CITY OF PORTLAND, MAINE  
DEVELOPMENT REVIEW APPLICATION  
PLANNING DEPARTMENT PROCESSING FORM  
DRC Copy

2005-0209  
Application I. D. Number  
8/31/2005  
Application Date  
Single Family Home Lot#7  
Project Name/Description

Consultant/Agent  
Agent Ph: \_\_\_\_\_ Agent Fax: \_\_\_\_\_  
Applicant or Agent Daytime Telephone, Fax  
Proposed Development (check all that apply):  
 New Building  Building Addition  Change Of Use  Residential  Office  Retail  
 Manufacturing  Warehouse/Distribution  Parking Lot  Other (specify) \_\_\_\_\_  
1408 sq ft  
Proposed Building square Feet or # of Units  
12750  
Acreage of Site  
72 - 72 Ruby Ln., Portland, Maine  
Address of Proposed Site  
342 B025001  
Assessor's Reference: Chart-Block-Lot

RUBY LANE
 (PROPOSED)

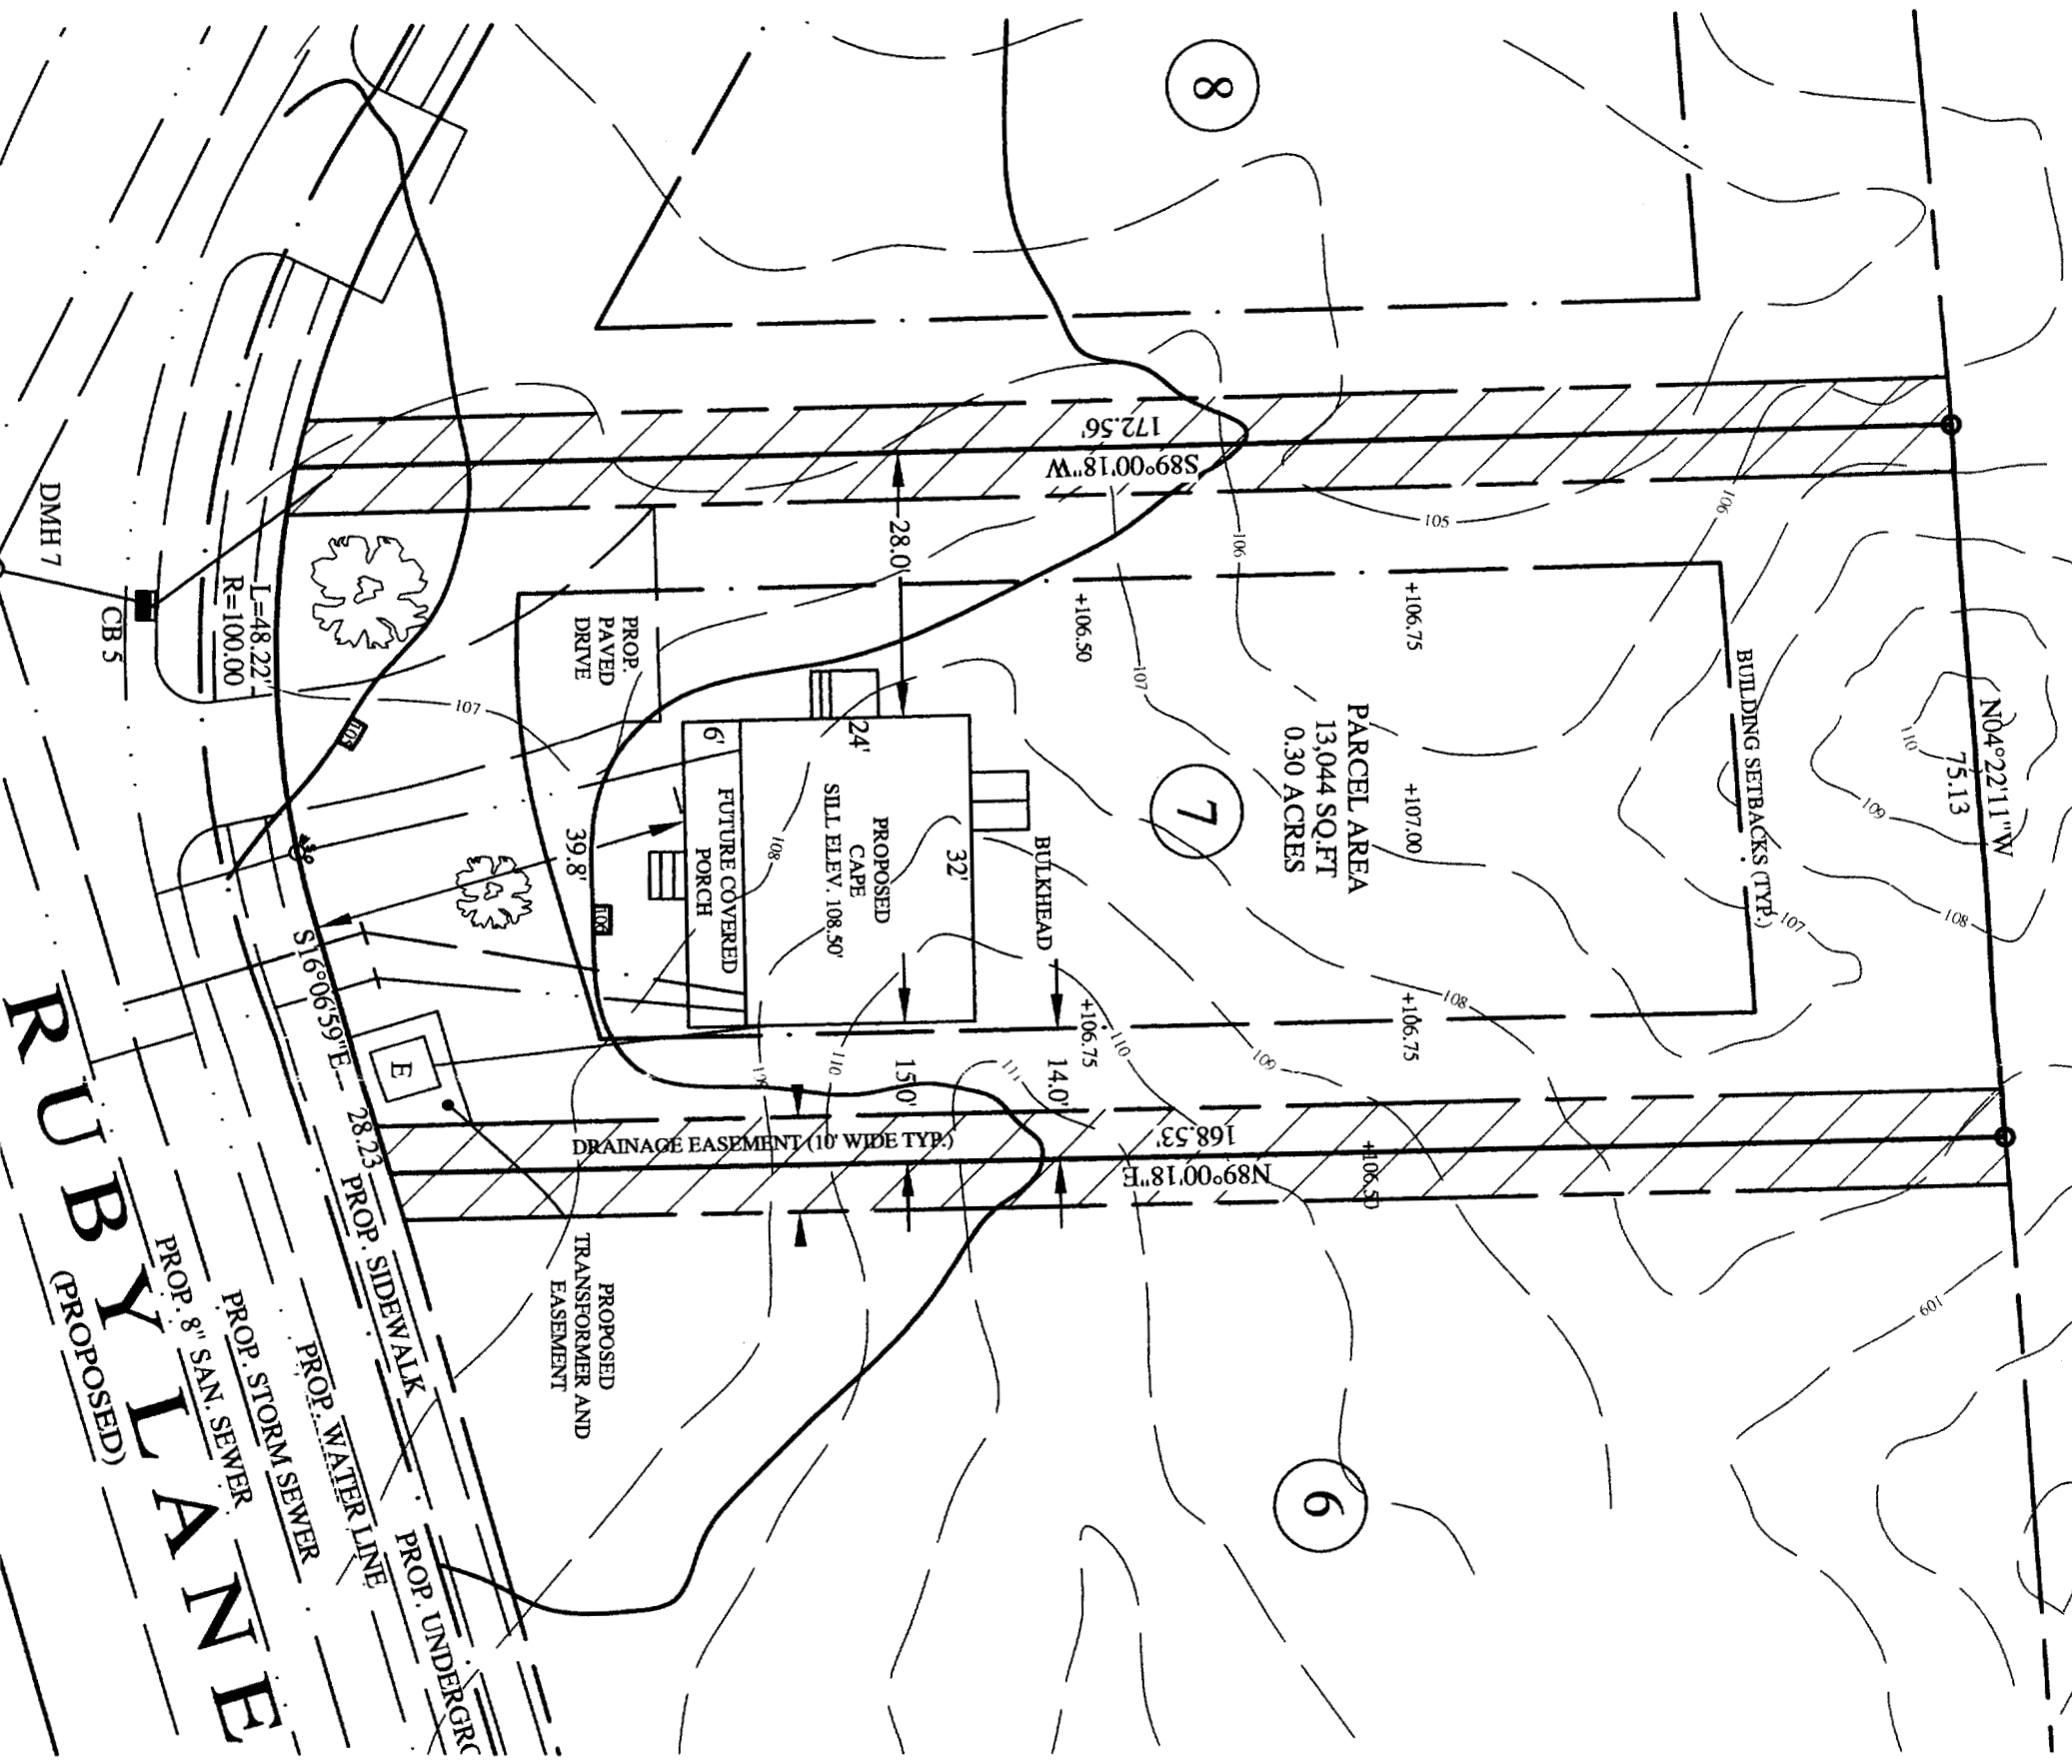
Plus Dist. Match drawings  
2 spaces out of setback  
Show exp./prop. topo.  
Silt fence  
Tree Preserve,  
Show 25' lot zone
